CITY OF ALBUQUERQUE

December 18, 2012

**Re: Leyba Body Shop, Lot 16A/Block 3, Mesa Verde Addition, 103 Tennessee NE
Grading and Drainage Plan
Engineer's Stamp dated 12-07-12 (K19/D146)**

GRADING PLAN

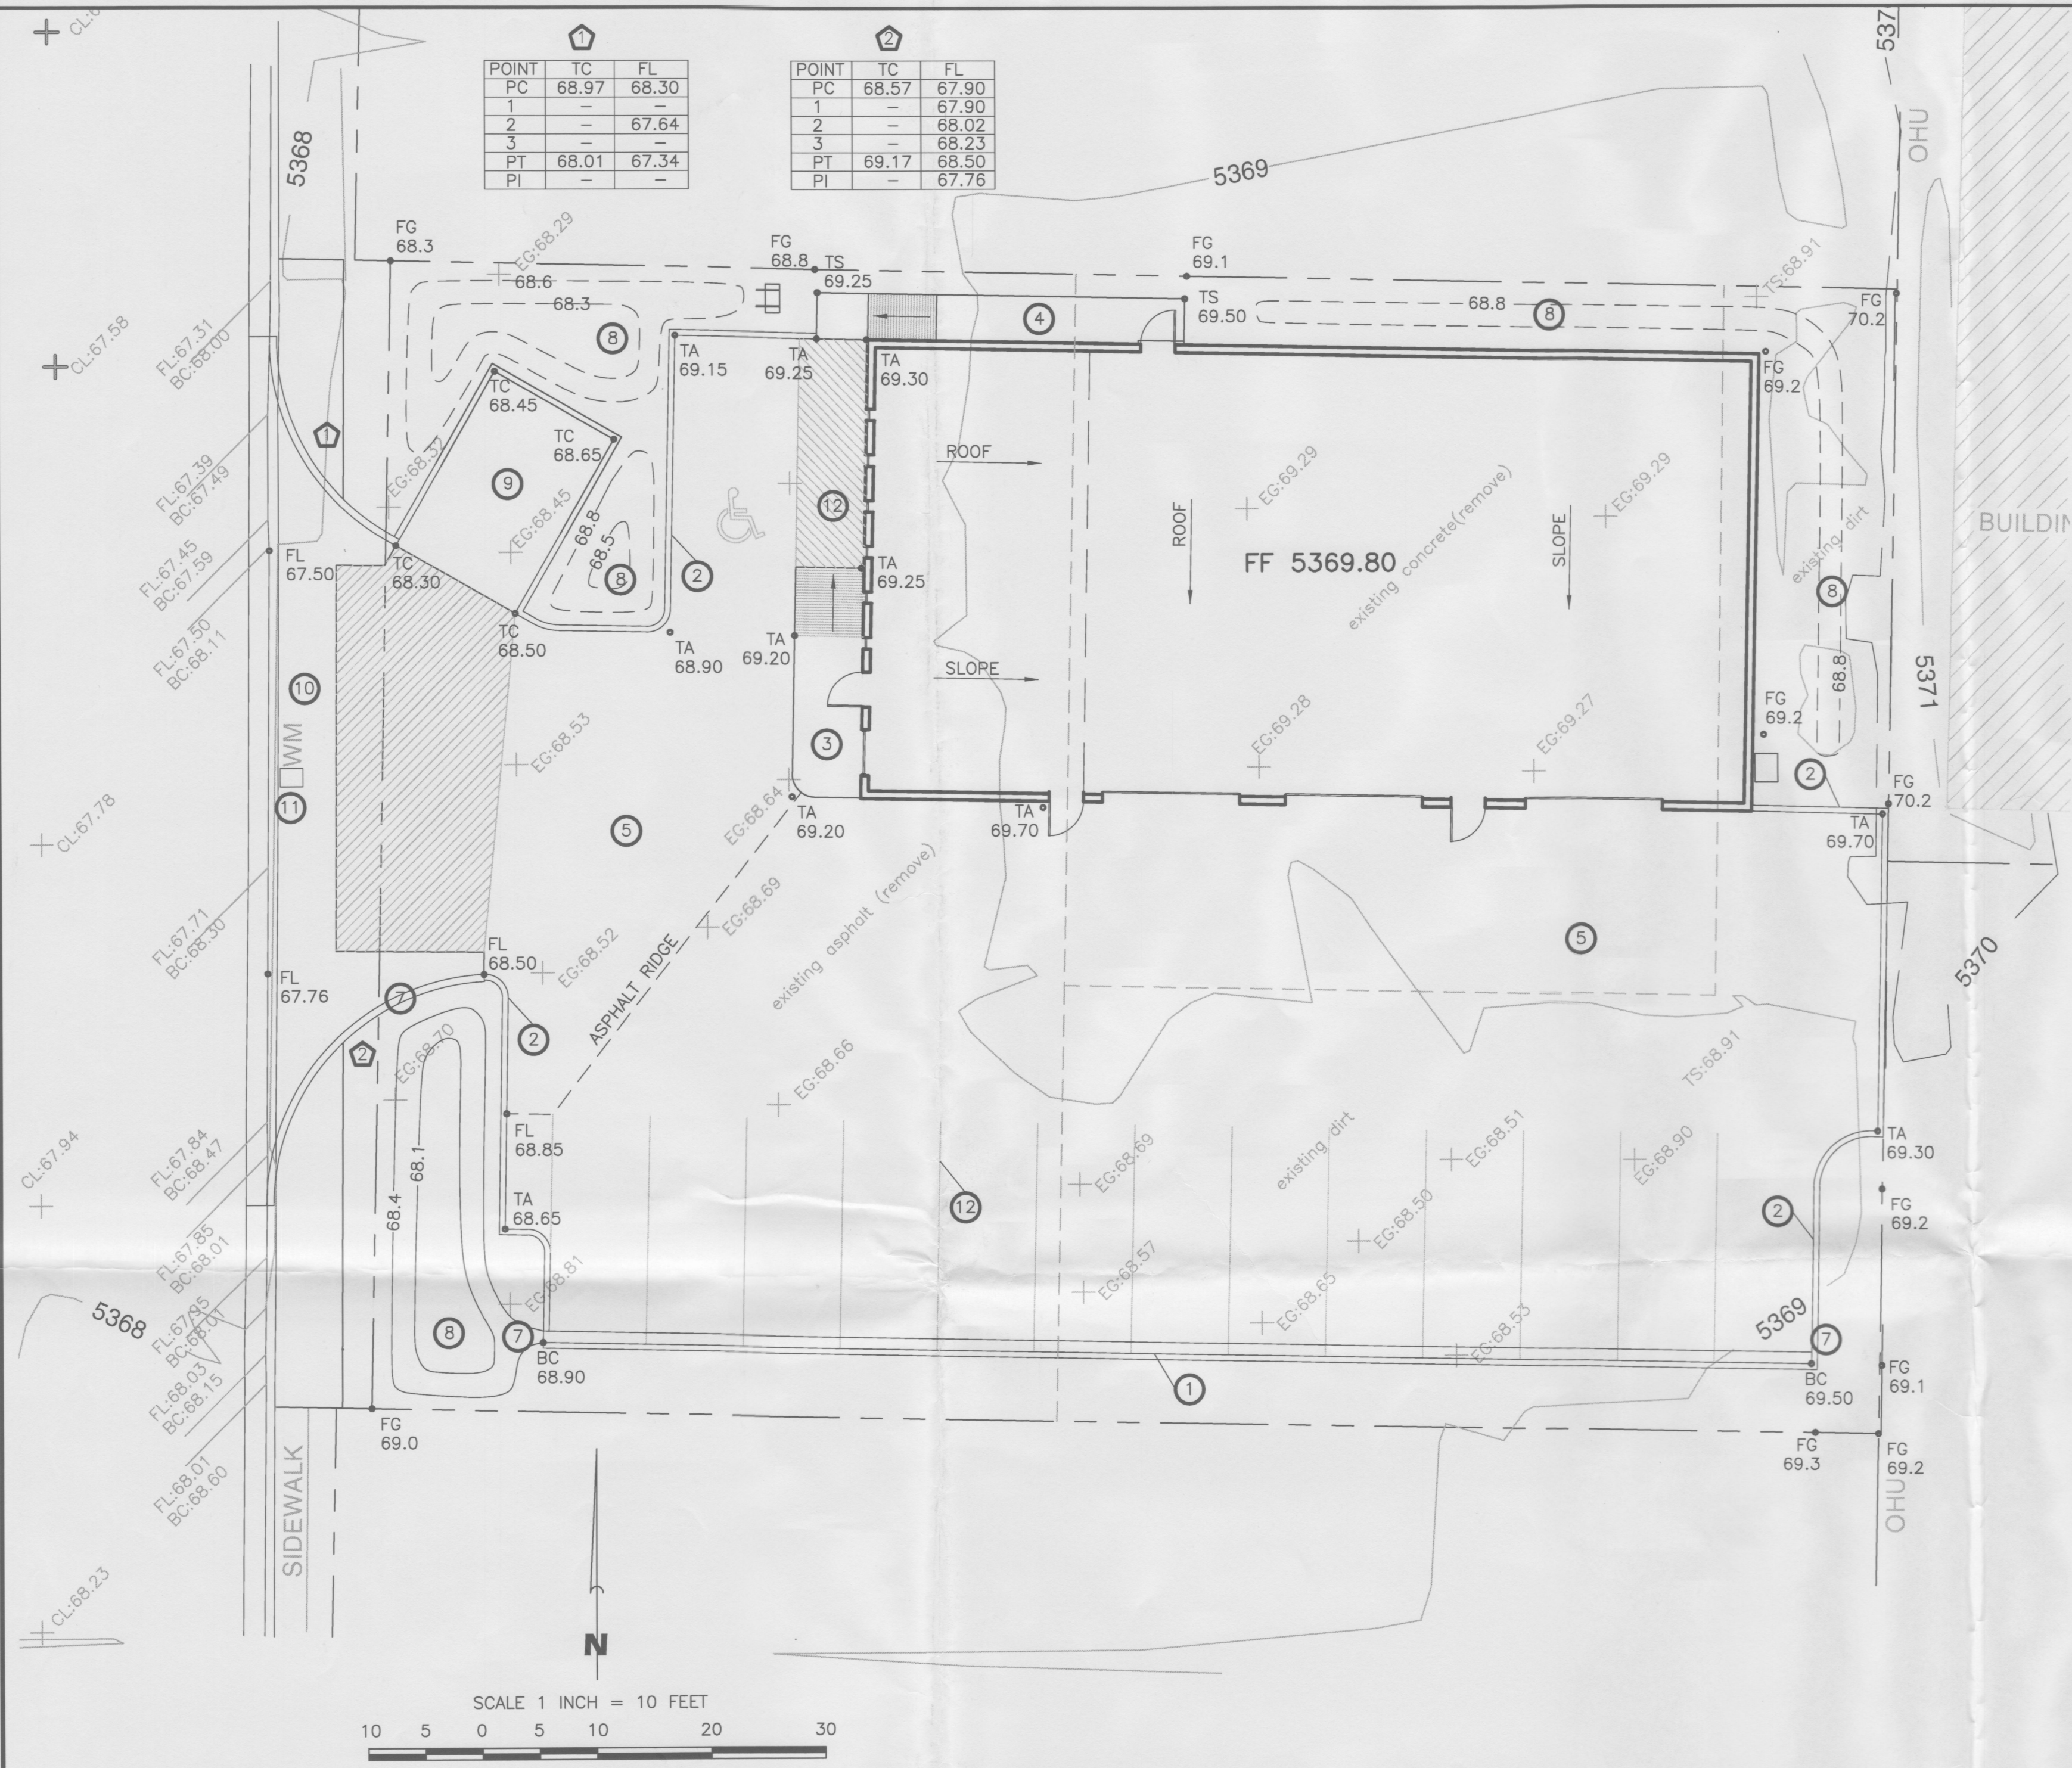
Based upon the information provided in your submittal received 12-07-12, the above referenced report is approved for building permit. Hydrology is requesting that proposed landscape areas be depressed to retain/infiltrate the rain that falls on them.
